**ZONING COMMITTEE  
RECOMMENDATION  
July 30, 2008**

**Rezoning Petition No. 2008-080**

**Location:** Approximately 2.34 acres located on the southwest corner of Providence Road West and Marvin Road

**Request:** R-3, single family residential to INST (CD), institutional conditional district

Title: **SITE PLAN**

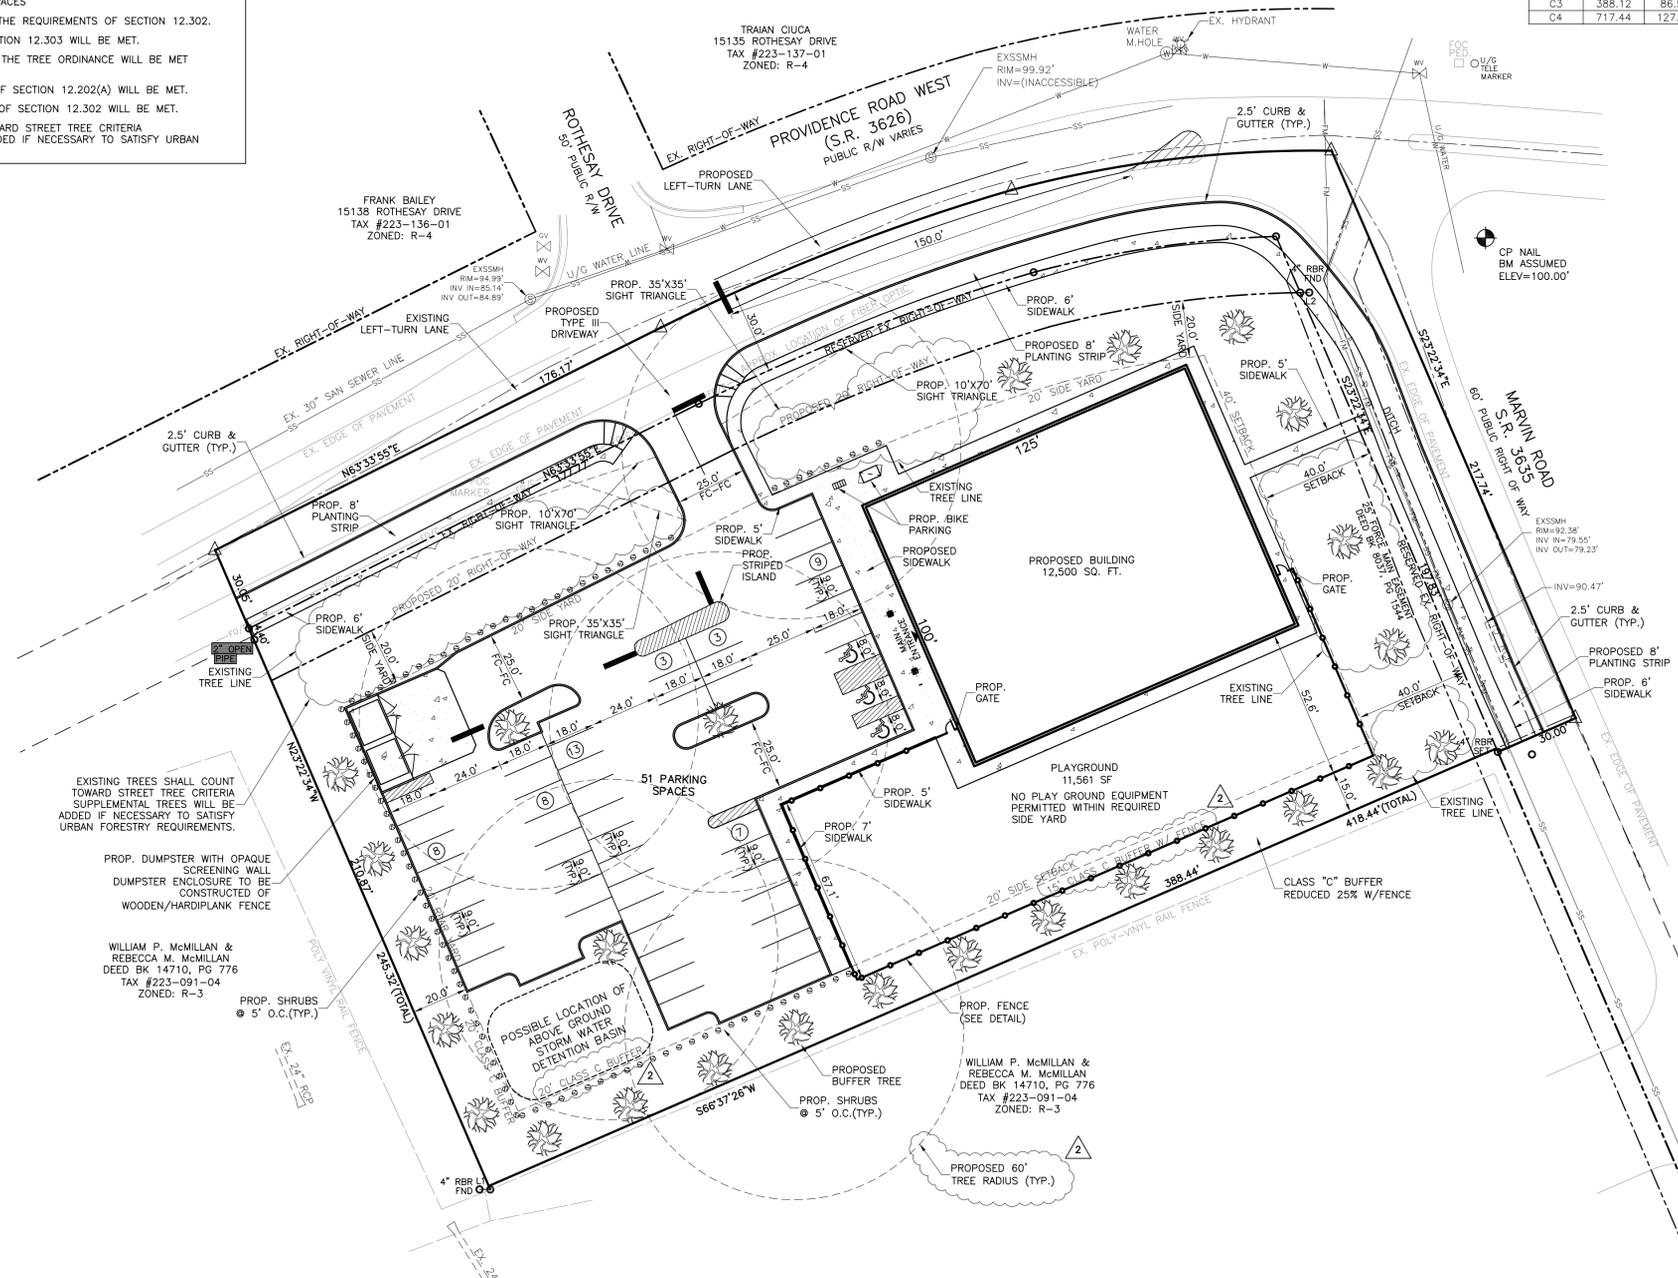
Mr. Drake that tree save area is not shown on the site plan and that no calculations of the size of the woodland buffer are provided. In addition, Stormwater's requested that the petitioner add the contact information for the wetlands permit to the site plan and this has not been added. While CDOT did not request a conveyance of the right-of-way along Marvin Road and Providence Road West, this could be added as a modification. The Zoning Committee should consider if the increase in the maximum number of children is significant enough to call for a new public hearing. This would be a Zoning Committee recommendation to Council. A discussion of this ensued, and the increase was not considered to be significant enough to warrant such a recommendation.

The Committee asked Ms. Volmer why the site was arranged so that the playground area was right next to the single-family districts/uses? Ms. Volmer noted that the footprint of the building has been reduced from 1,500 square feet to 1,250 square feet. A seven-acre single-family site lies to the south of the site, and 20-foot buffers have been provided along the residential adjoining property lines.

The Committee was concerned about the buffers: why is the buffer wider along the public streets than along the property lines abutting residential districts? Mr. Drake noted that the petitioner has agreed to dedicate the right-of-way along Providence Road West and Marvin, and the buffer is outside of this area, making the area look wider. The petitioner has also identified a Woodland buffer in these areas to preserve trees. The setback width along Marvin Road is 40 feet, while the Class C buffer to the south is 20 feet.

A Commissioner asked why the parking lot, playground area, and storm water detention pond are all located near the single-family property lines, with only a 20-foot buffer width. Mr. Drake noted the petitioner is proposing to construct the full, required 20-foot buffer, and will not reduce the size of the buffer.

Another question was raised by the Committee about the height of the lighting. Note #2 on the site plan stated that all lighting will be full cut-off and shielded so as not to cast light directly on the public rights-of-way or adjacent residentially used/zoned property. There is no information on the height of the lighting.
